Comment for planning application 18/00825/HYBRID

Application Number 18/00825/HYBRID

Location Heyford Park Camp Road Upper Heyford Bicester OX25 5HD

Type of Comment Objection

FIGURE 6.1
**Highway Network/
Proposals Plan**

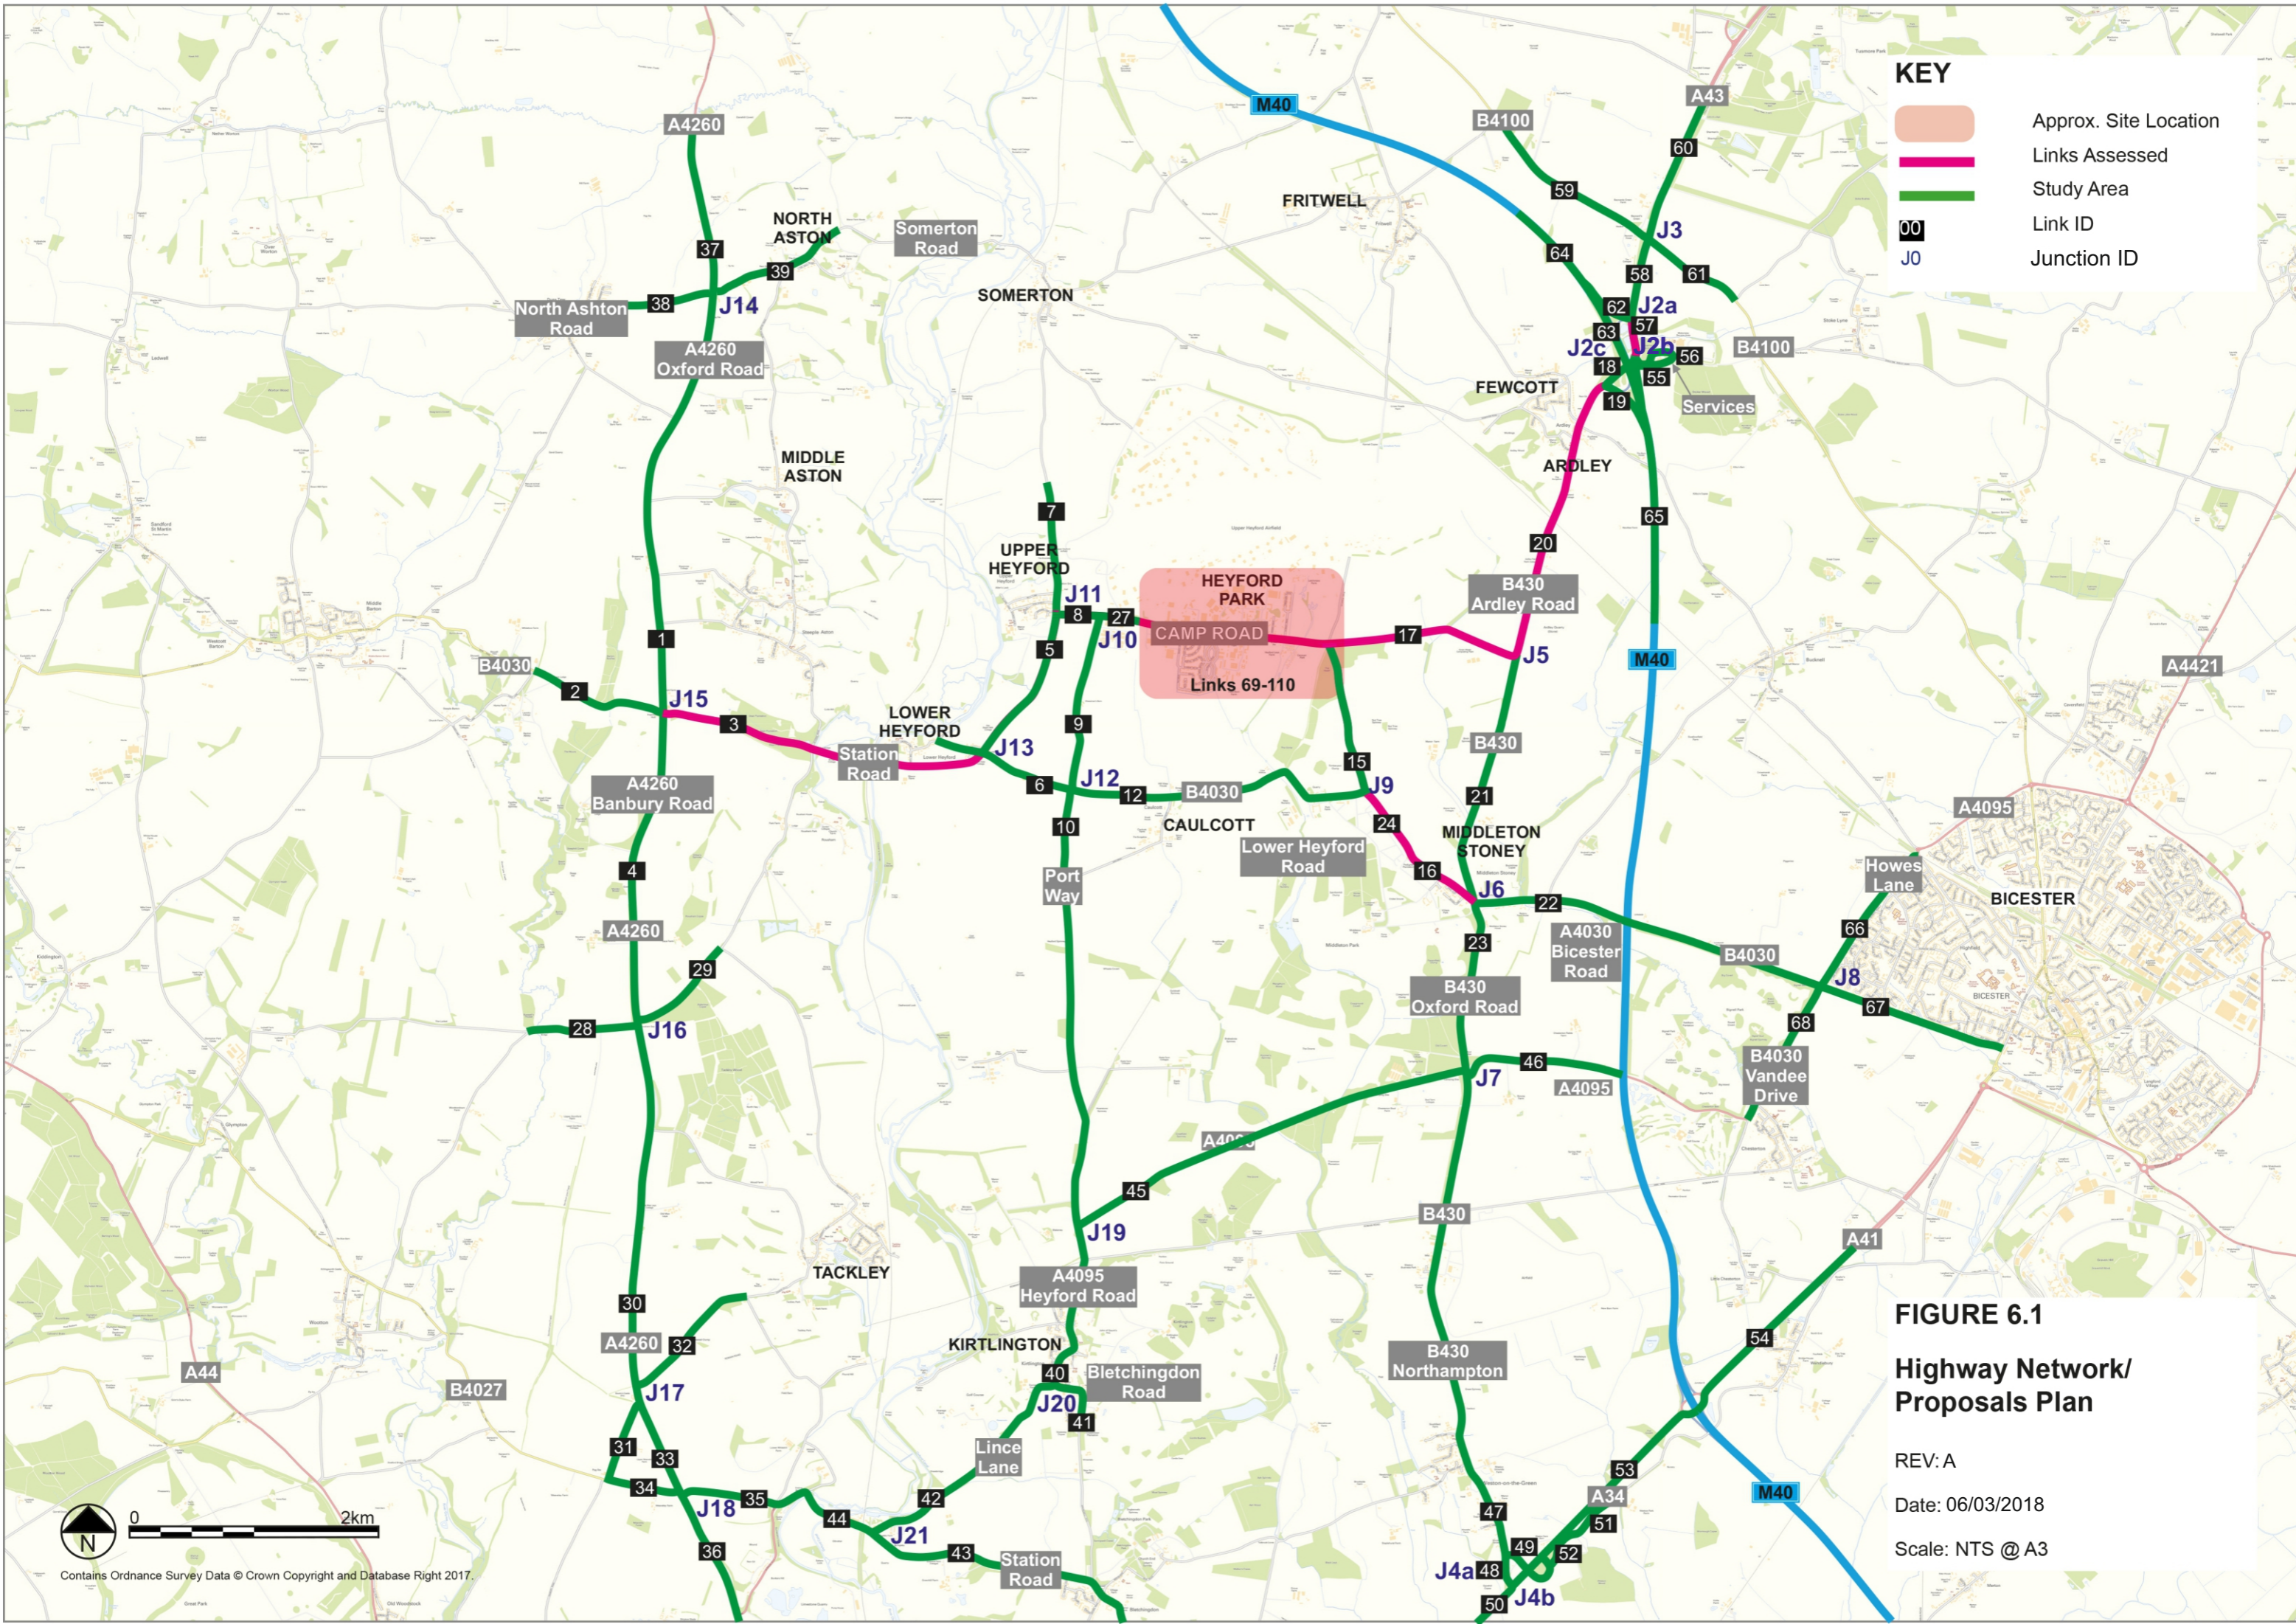
Comments This comment relates to the proposal for a Busgate at J9 on your plan ES SE CH 6 Fig 6.1- Highways Network Proposals Plan, and proposed closure of the B4030 road from J9 to J6 on your plan (Middleton Stoney Traffic Lights). Any road closure on this route will have a seriously adverse effect on the traffic through neighbouring villages in particular Ardley, Somerton and North Aston and as far as Duns Tew and further west forcing traffic onto unclassified roads in rural farming areas. In the case of North Aston, diverting traffic from the B4030 Heyford Road will push traffic onto narrow unclassified roads through Cherwell Vally Conservation areas where roads are, in many instances, single vehicle width, which include hump back and narrow bridges with weight restrictions, a low railway bridge and areas subject to regular flooding. In the villages, many houses are immediately adjacent to the roadway where increased vehicle traffic will cause increased danger to residents and to pedestrians where there are no pavements. Danger from residential accesses with very low vehicle visibility which cannot be improved but only mitigated by traffic calming measures and restriction on vehicle movements. Increased traffic on these small village roads might be considered more closely and alternative traffic calming solutions proposed rather than closure of the B4030. The proposal to close the B4030 with a Busgate only seems to have considered the residents of Heyford Park and those of Middleton Stoney and ignored the interests of other local villages who have used this access from the North Cherwell valley to Bicester over many centuries. I hope this proposal will be reconsidered.
